# PORTLAND MAINE

Project Name: Pomeroy Street Single Family Home  
& Street Construction

ID: 2012-471  
CBL: 193-E-1

On June 27, 2013, the Planning Authority approved with conditions a Level II site plan for the construction of approximately 200' of Pomeroy Street and a Level I: Minor Residential site plan for the associated single family home to be located at 11 Pomeroy Street. The decision is based upon the application, documents, and plans as submitted by Chabad Lubavitch of Maine, Inc., prepared by BH2M, and dated 6/19/13. The proposal was reviewed for conformance with the standards of Portland's land use ordinance, including Sections 14-526 (Site Plan) and 14-403 (Street Access).

SITE PLAN
 LEVEL I-MINOR RESIDENTIAL DEV.
 LEVEL II-ROAD IMPROVEMENTS
 LAND OF
 CHABAD LUBAVITCH OF MAINE INC.
 POMEROY STREET
 PORTLAND, MAINE

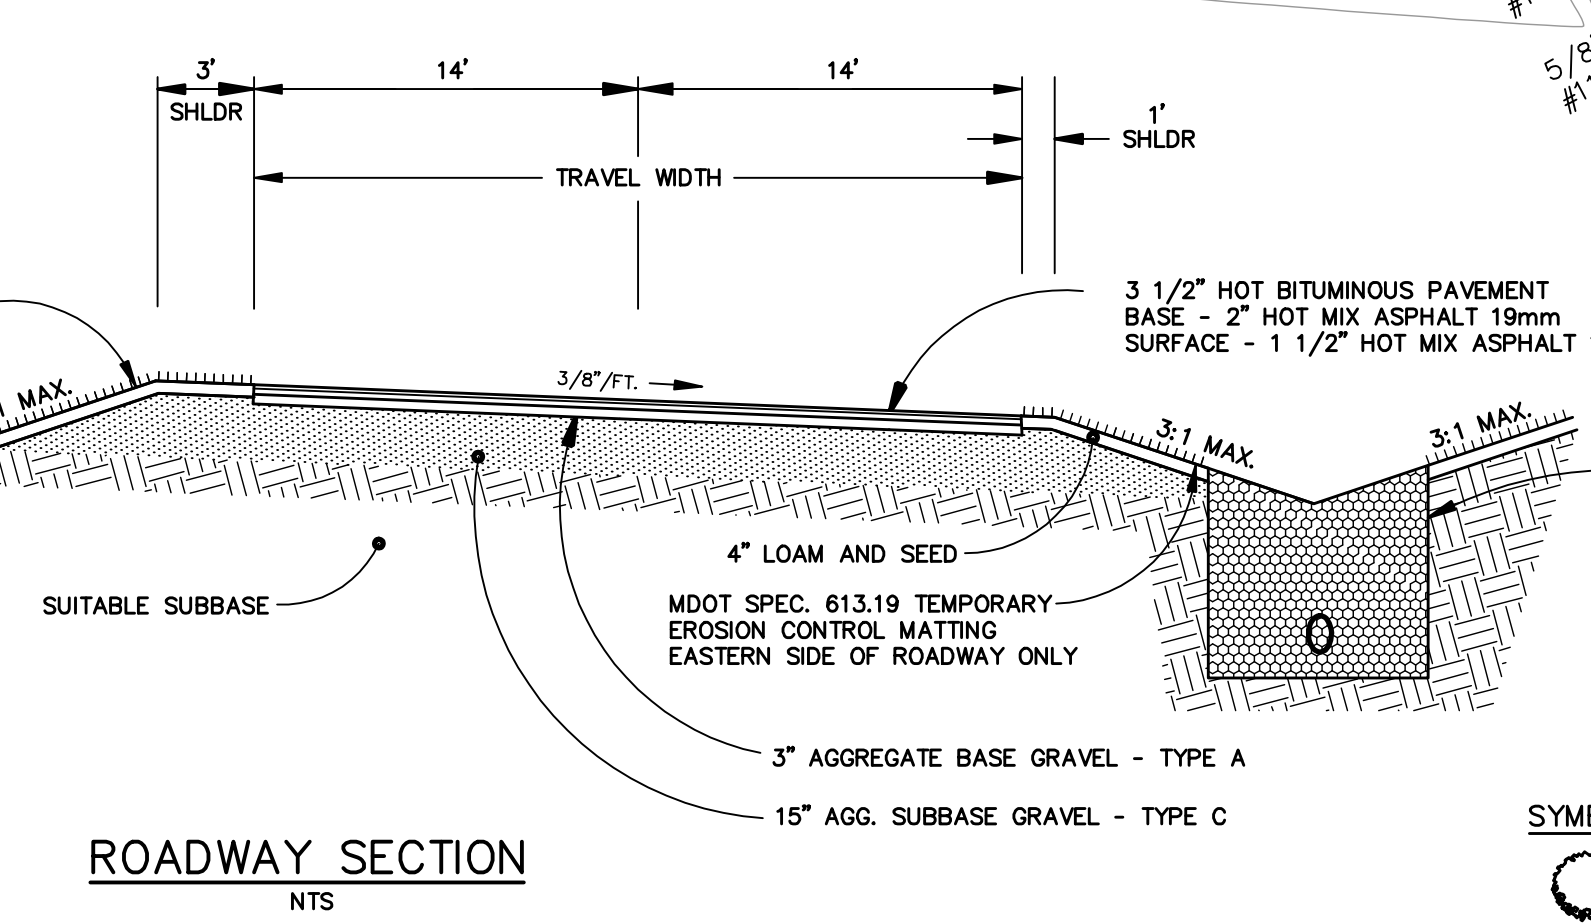
3. The applicant shall provide a copy of the proposed landscaping easement to the neighboring properties, for review by the city's Planning Authority;
4. The applicant shall revise the site plan to include a note stating that the applicant will meet with the city arborist to field locate the proposed street trees, so as to minimize impacts to the roadside drainage and underground utilities, for review by the city's Planning Authority;
